# CITY OF ALBUQUERQUE

**RE: Rain Tunnel Car Spa  
5401 Sevilla Ave  
Grading and Drainage Plan  
Engineer's Stamp Date 2/27/17 (File: F11D016)**

Based upon the information provided in your submittal received 3/9/17, the Grading and Drainage Plan cannot be approved for Building Permit until the following are addressed:

EROSION & SEDIMENT CONTROL PLAN

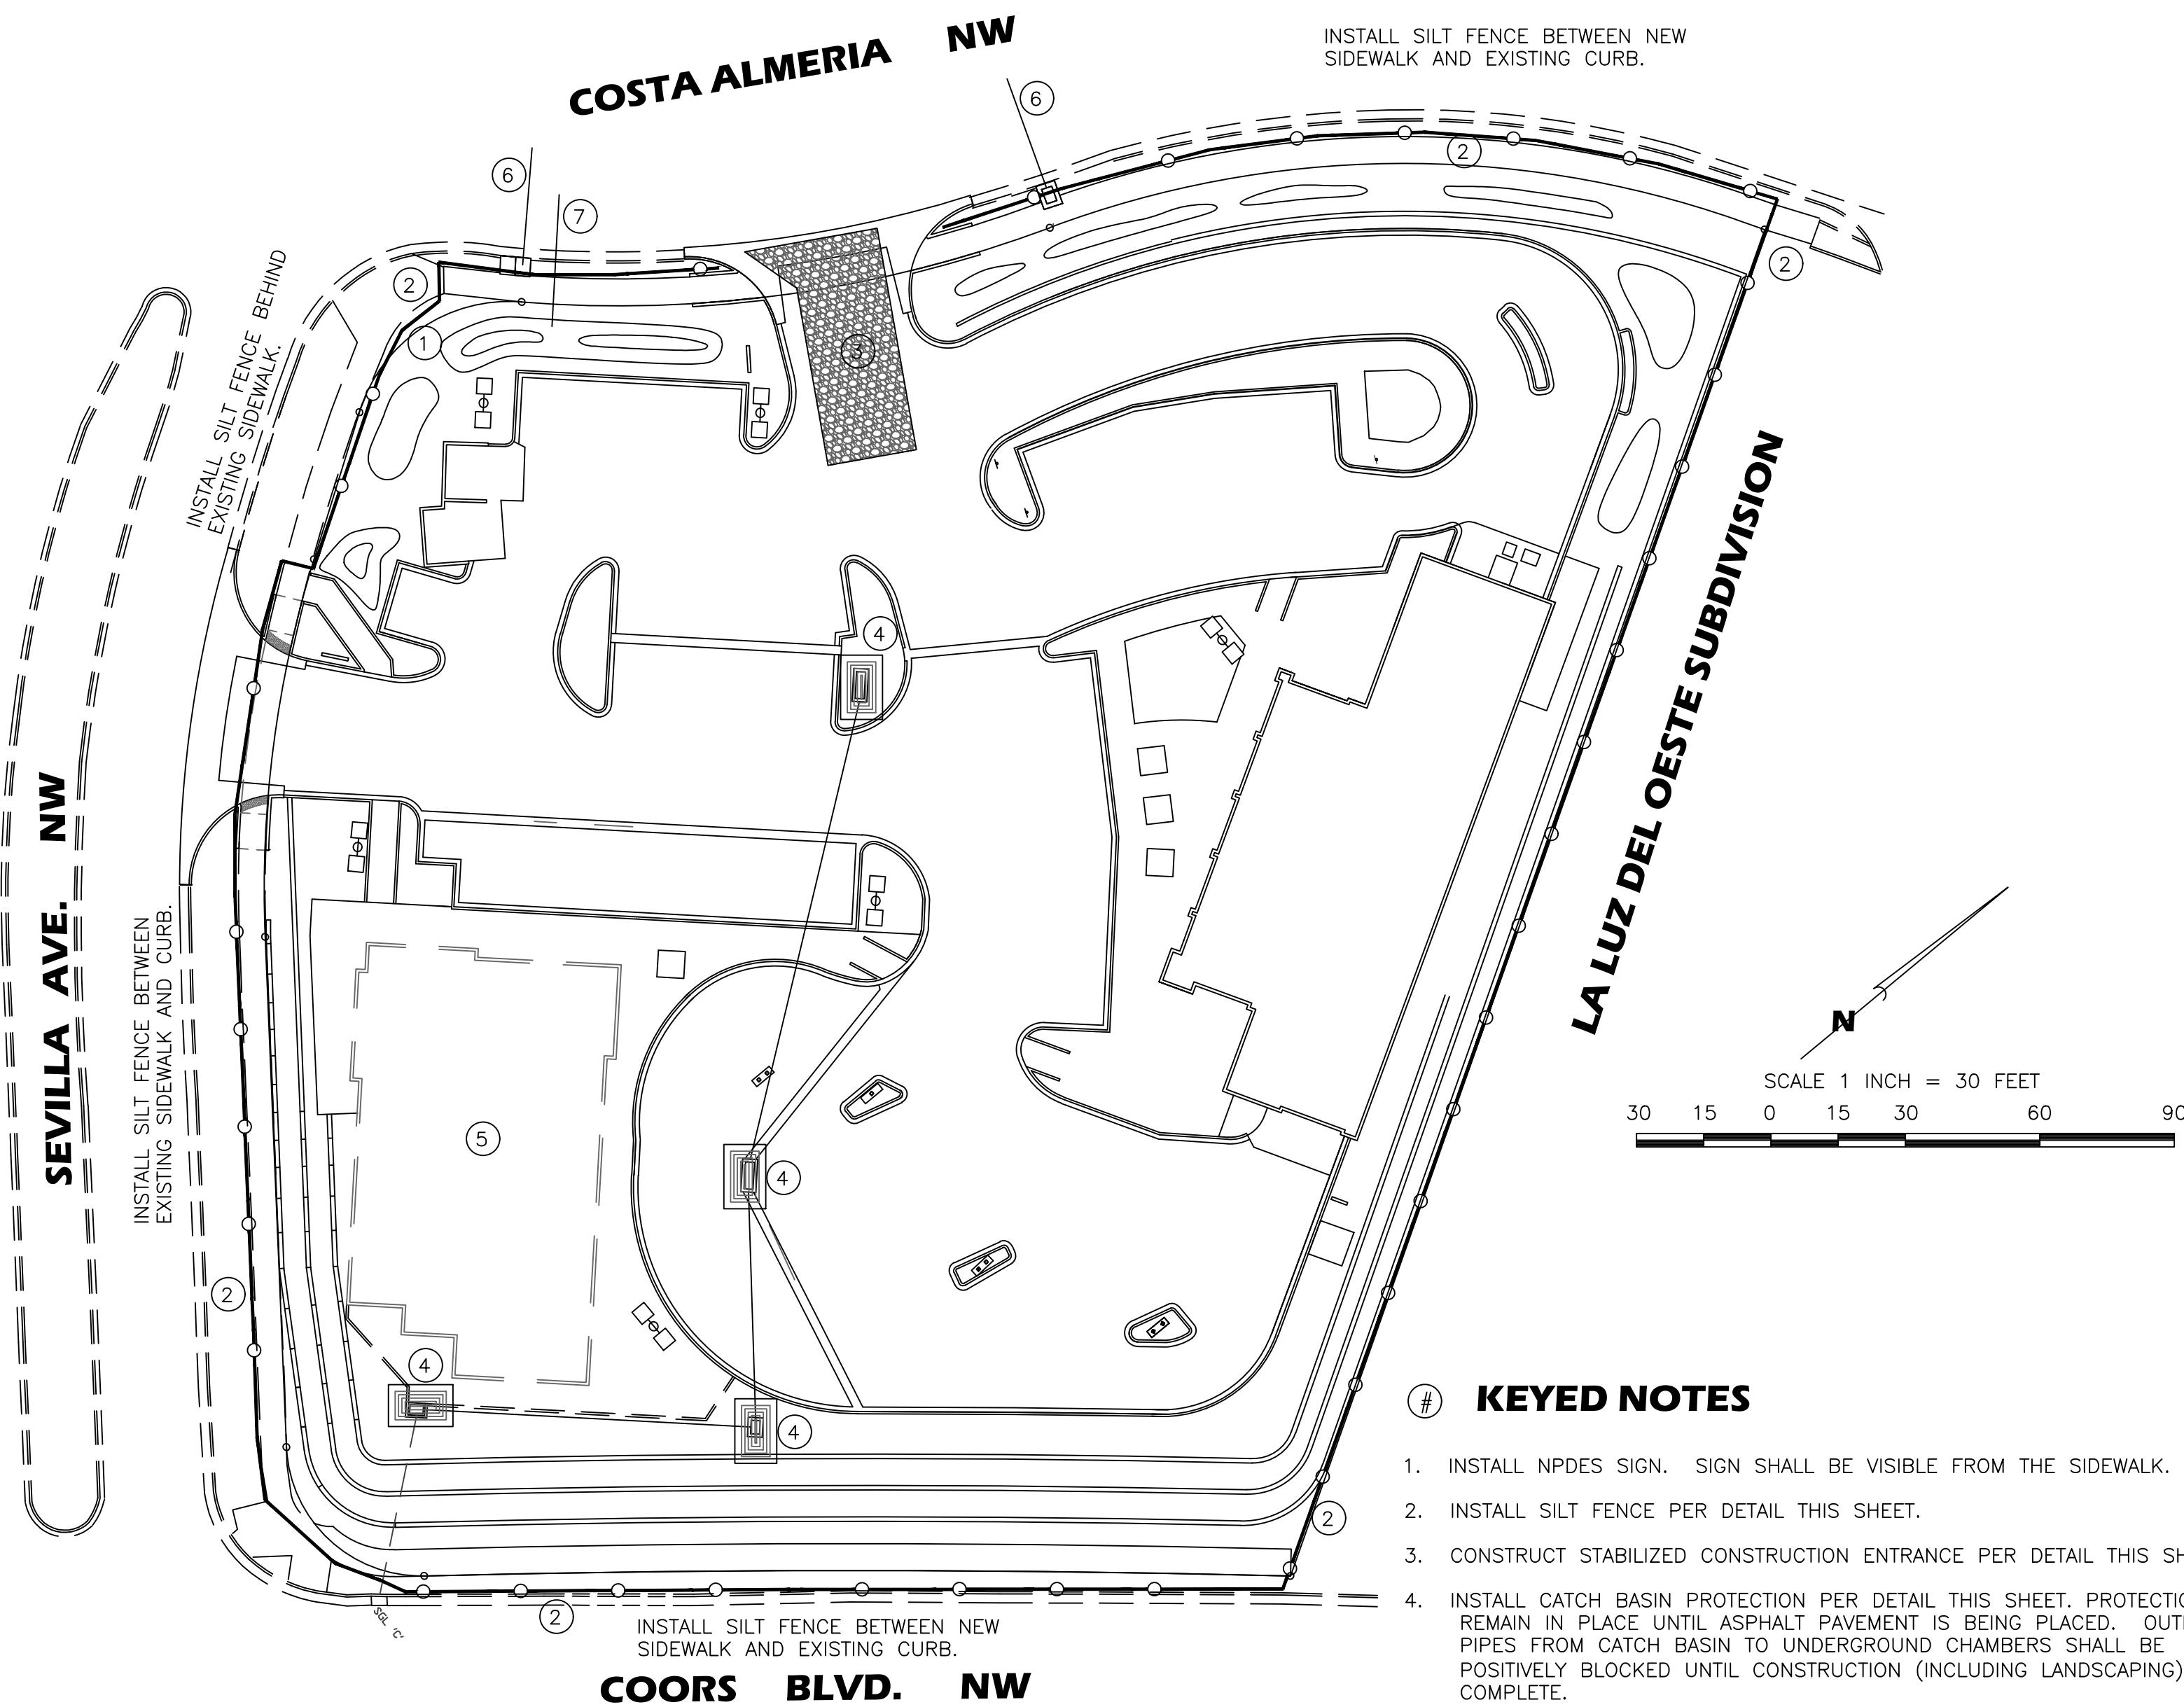
7. This work requires an Erosion and Sediment Control Plan to be submitted to the storm water quality engineer (Curtis Cherne, PE, [ccherne@cabq.gov](mailto:ccherne@cabq.gov)).

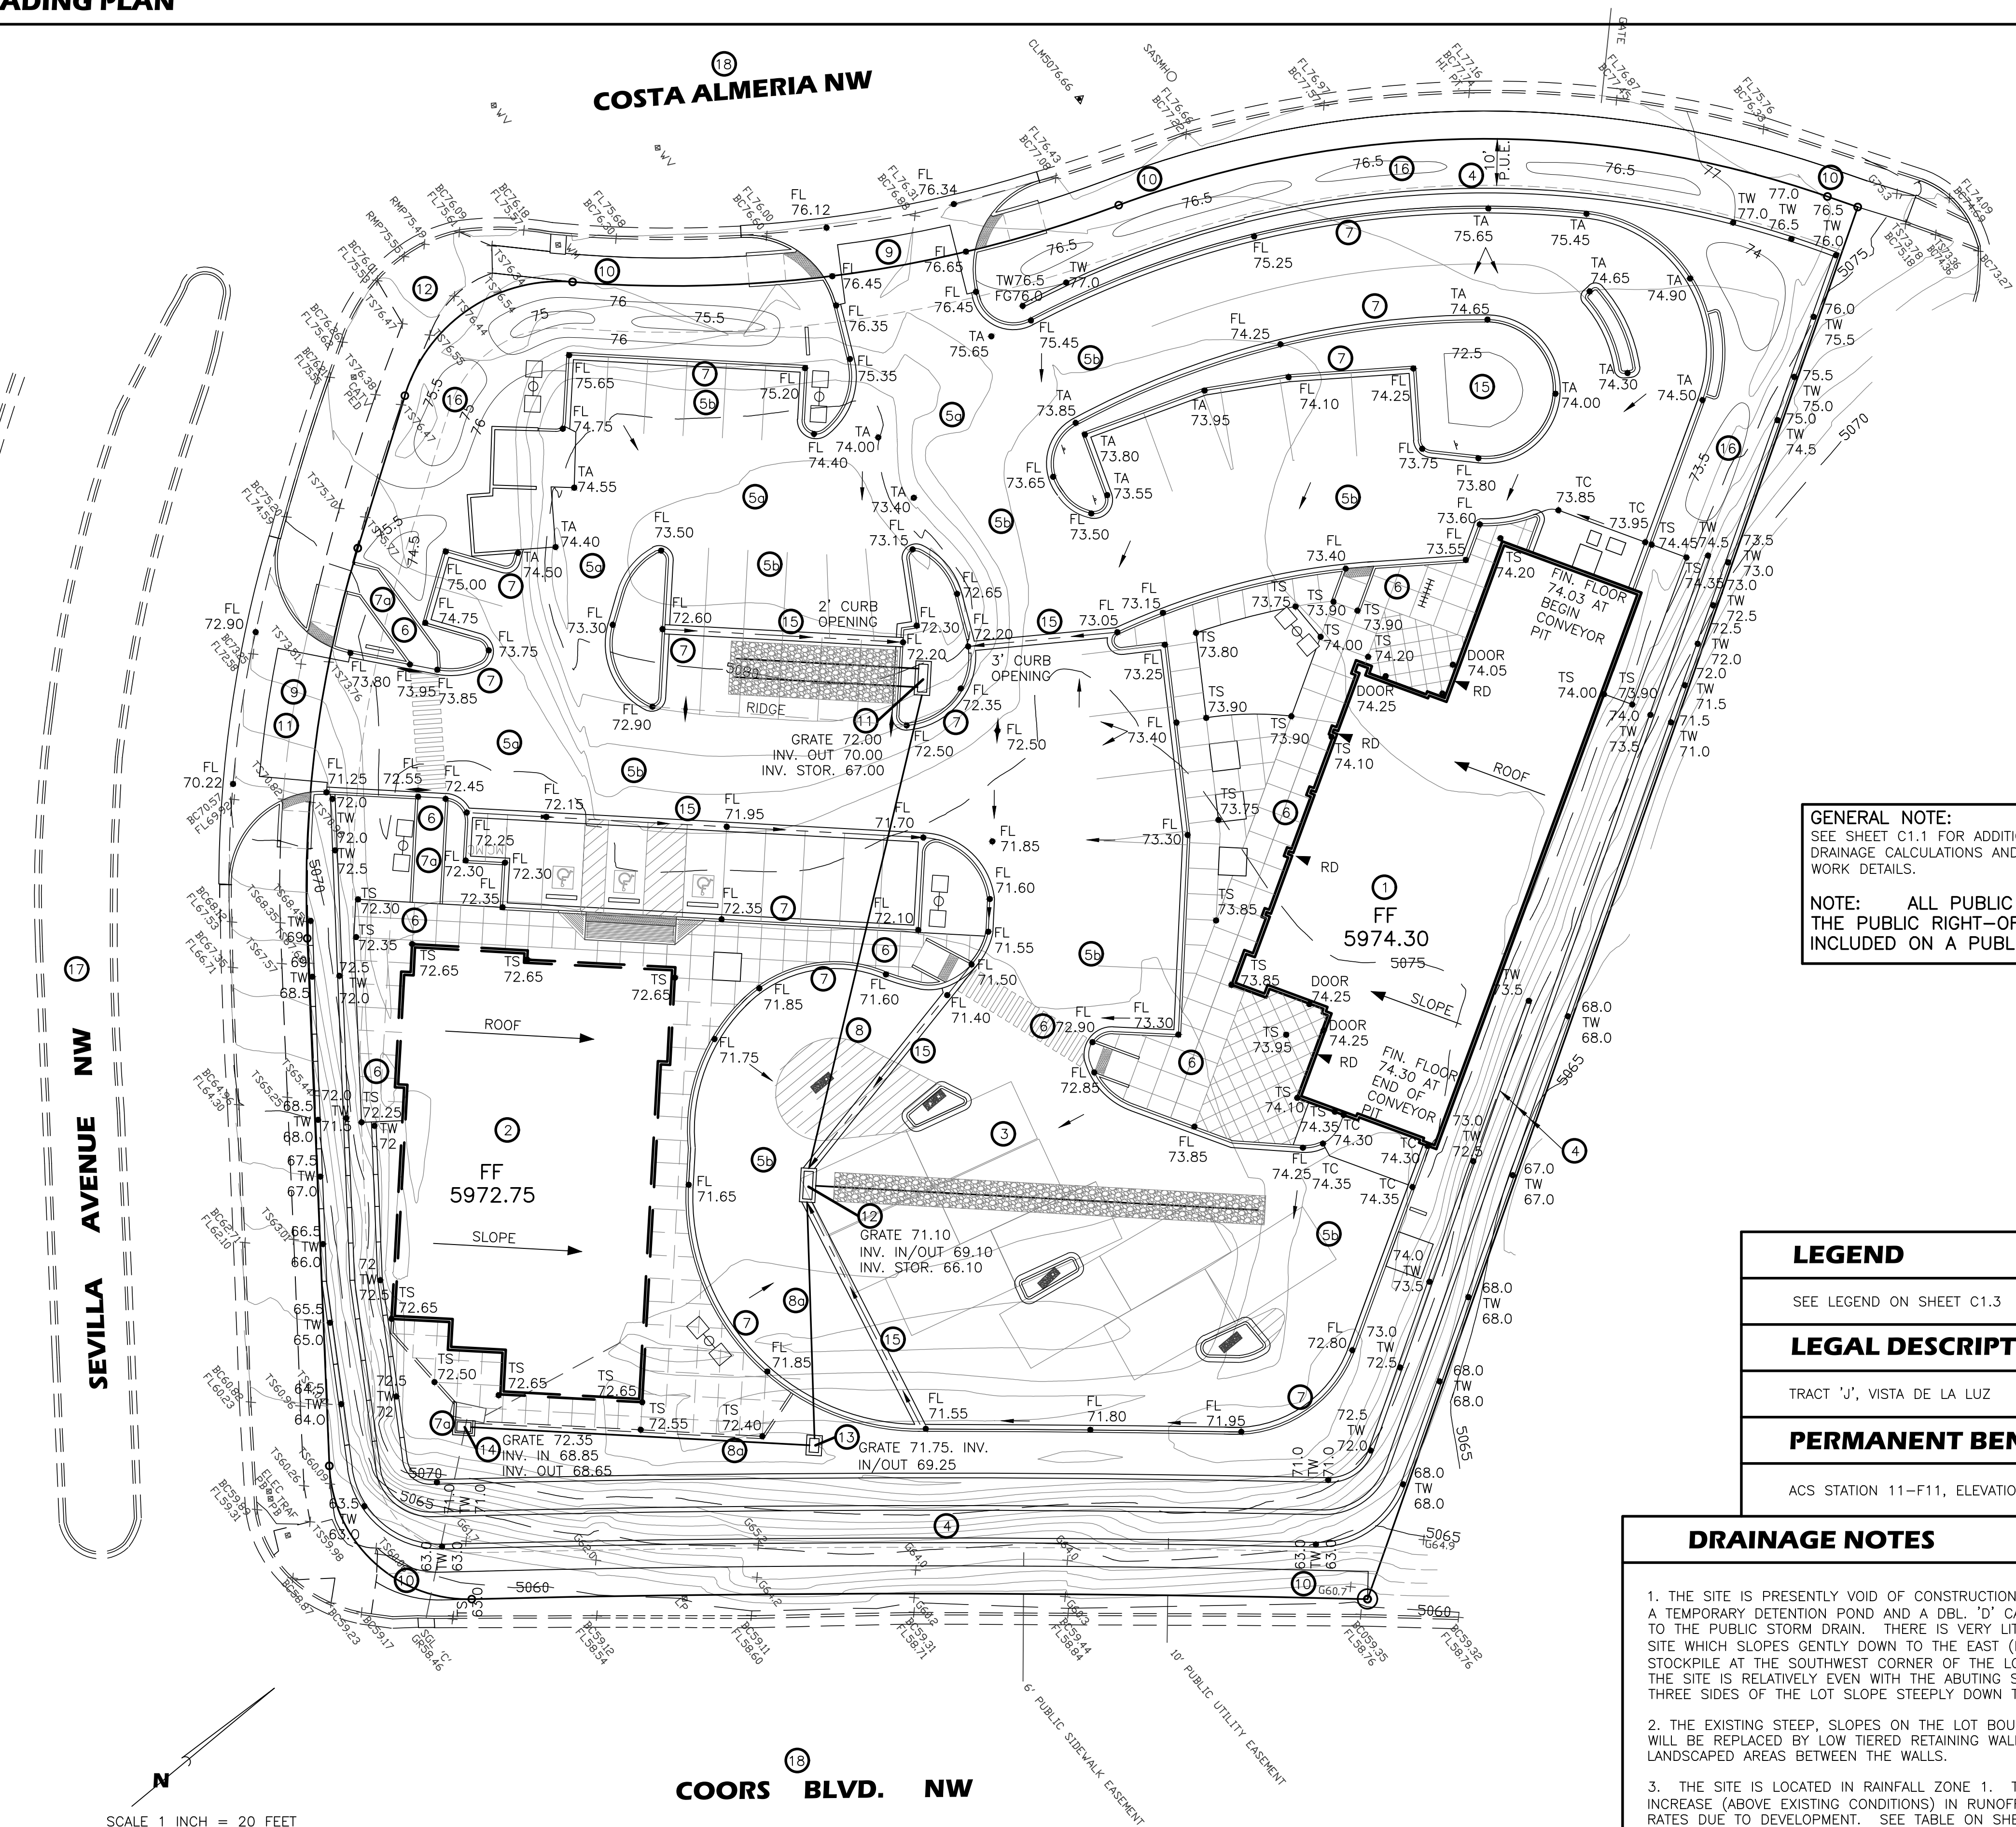
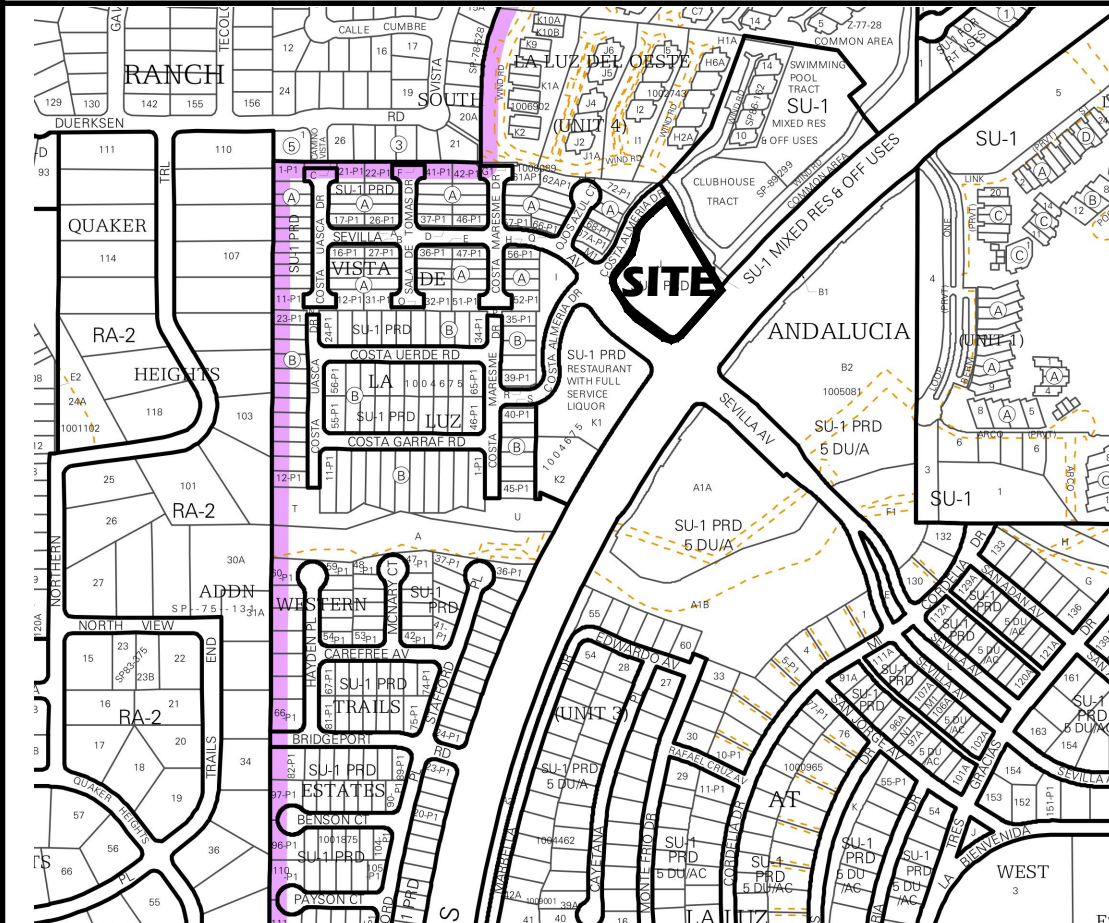
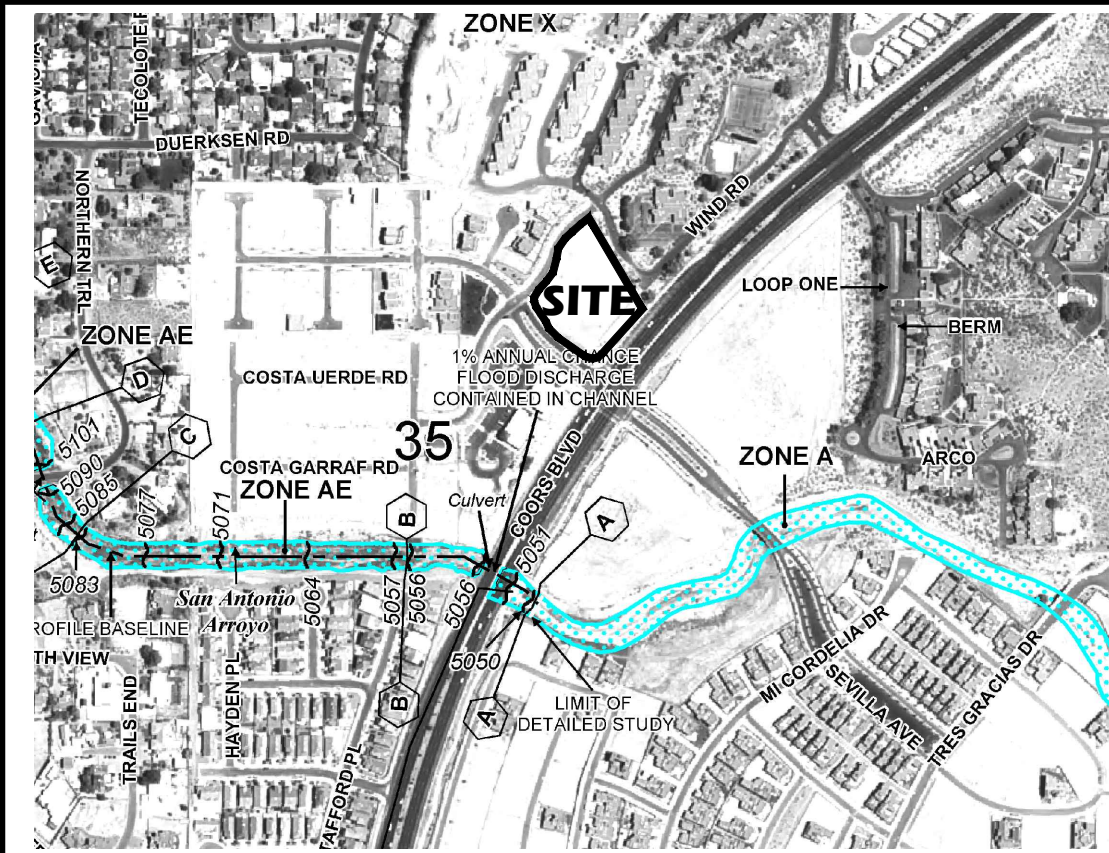
5. Provide a waterblock, at least 0.87' high, at the entrance off Costa Almeria.

6. Confirm placement of keyed notes; several look out of place such as #11 at the entrance off Sevilla and #15 in the northern parking island.
